**APPROVED**  
Limited liability only. Permit holder responsible for full compliance with the code.

02/26/2024

Addition & Renovations to  
**The Turlington Residence**  
 Sheet Title  
**Existing Conditions**

705 Building Section
Scale: 1/4" = 1'-0"

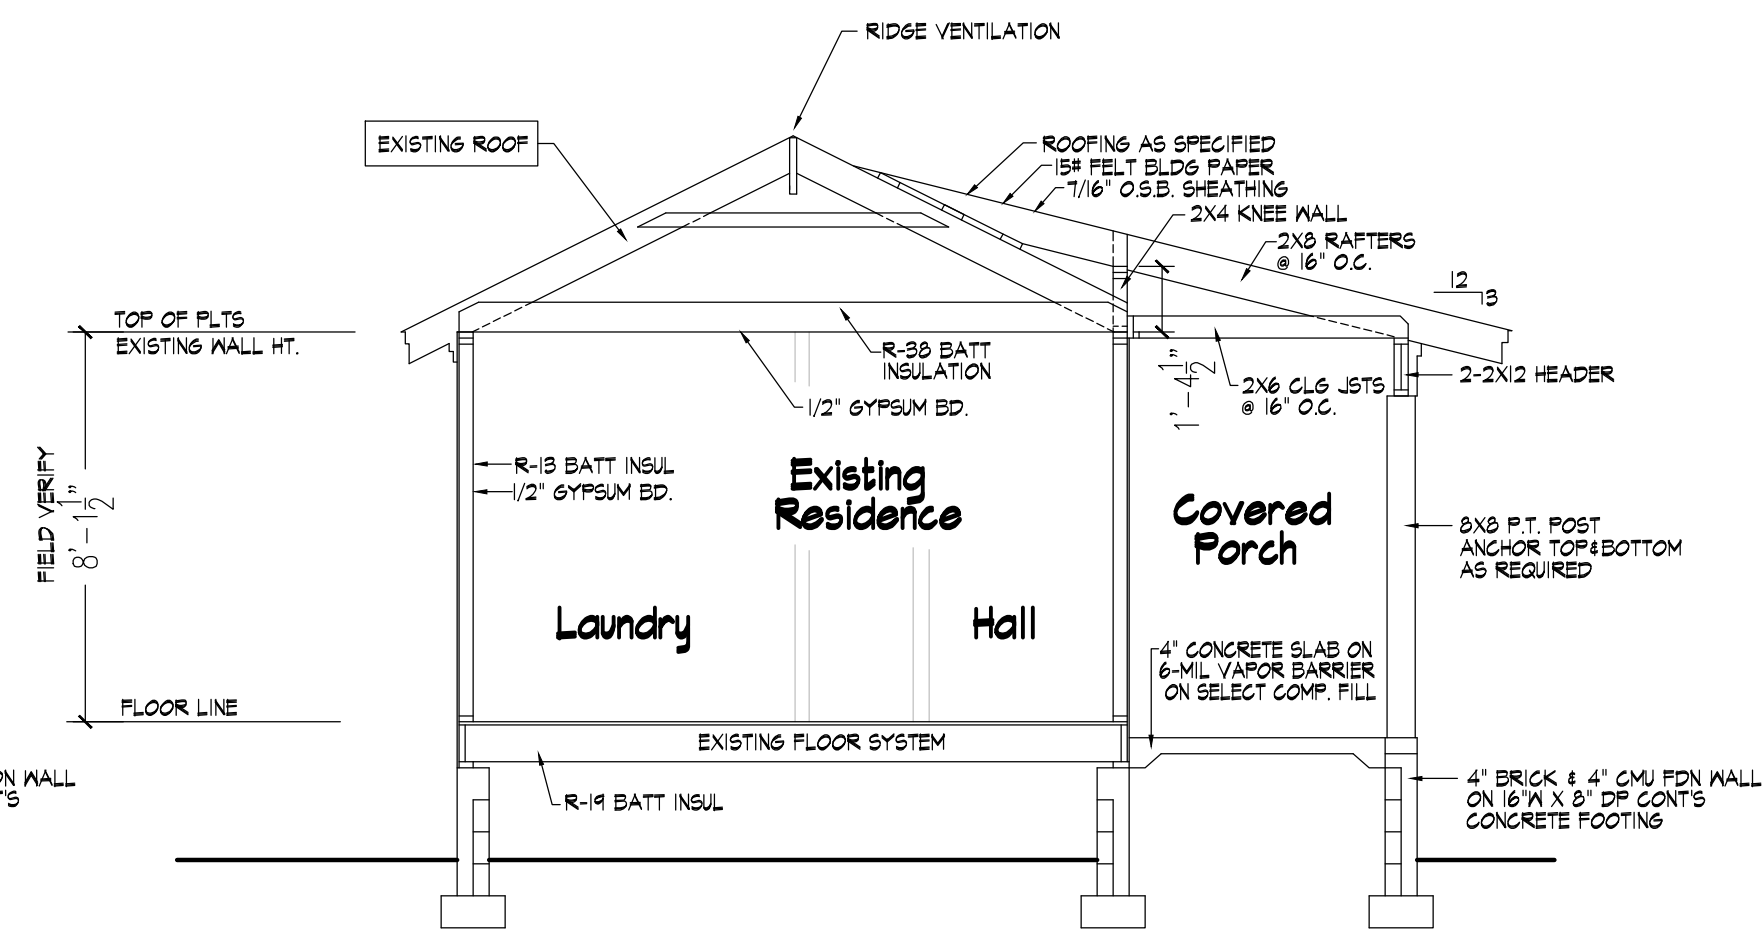
This should be designed as a beam, to support roof load and prevent rafter thrust. Collar ties are not designed to prevent rafter thrust
